CITY OF PORTLAND

BUILDING PERMIT

Job ID: 2011-03-543-SF

has permission to New 1,598 sf Single Family Home

ROOF PLAN
1/4" = 1'-0"

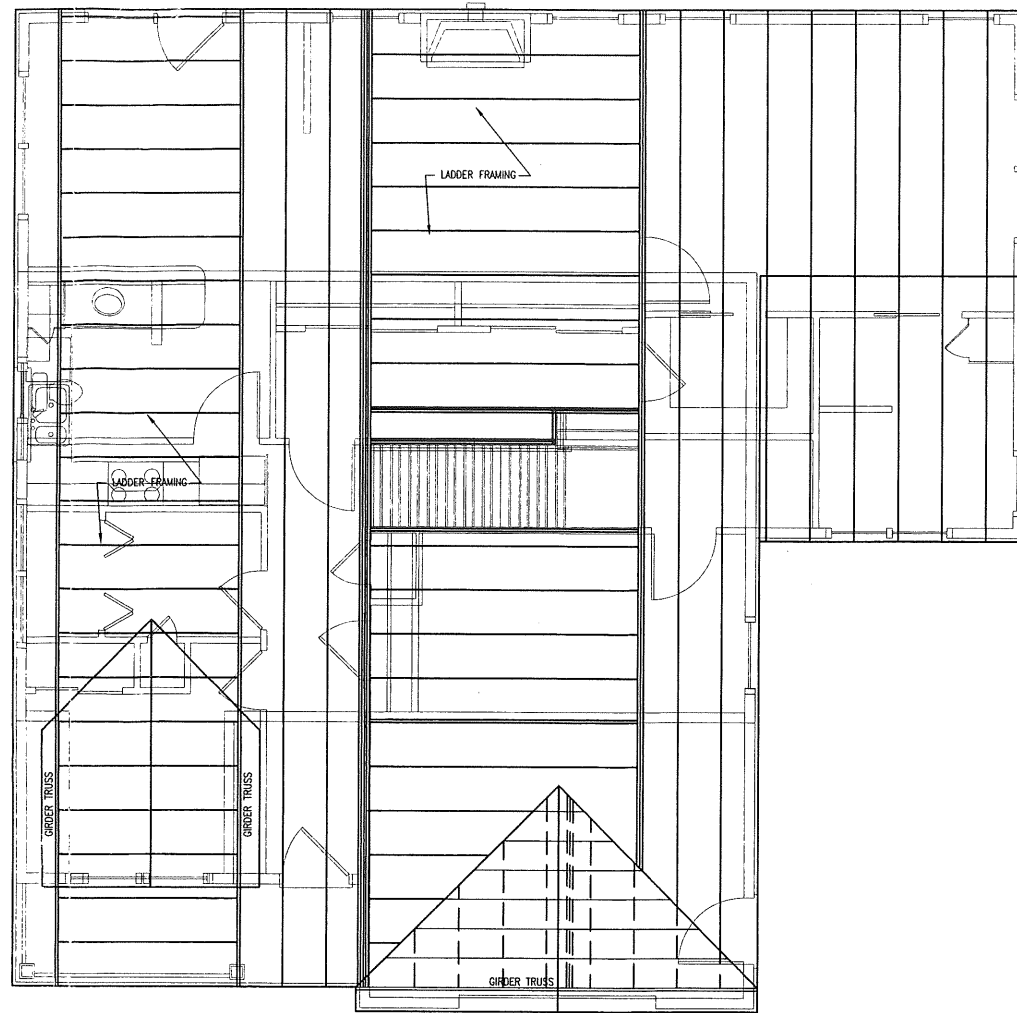
Pitch, Span, Spacing & Dimension (Table R802.5.1(1) - R 802.5.1(8)) Roof Rafter; Framing & Connections (Section R802.3 & R802.3.1)	8 ¹² Trusses @ 24" O.C	① Need specs 40 PSF
Sheathing; Floor, Wall and roof (Table R503.2.1.1(1))	Roof: 5/8 w/ Pent Edges Wall: 7/16 & 1/2 Ext.	
Fastener Schedule (Table R602.3(1) & (2))		②
Private Garage (Section R309) Living Space ? (Above or beside) Fire separation (Section R309.2)	(i) Hour Rated Ceiling w/ 3/8 Type X (ii) Hour Rated Walls w/ 5/8 Type X	
Opening Protection (Section R309.1)	"3068 Rated" Shown	20 Min Fire Door Required.
Emergency Escape and Rescue Openings (Section R310)	Egress Window Shown	Okay
Roof Covering (Chapter 9)	30yr Architectural	Okay
Safety Glazing (Section R308)	Master Bath 1st Floor Tub Required	③
Attic Access (Section R807)	22x30" Required	④
Chimney Clearances/Fire Blocking (Chap. 10)		
Header Schedule (Section 502.5(1) & (2))	③ 2x10	⑤
Energy Efficiency (N1101.2.1) R-Factors of Walls, Floors, Ceilings, Building Envelope, U-Factor Fenestration	Ceiling R-49	⑥
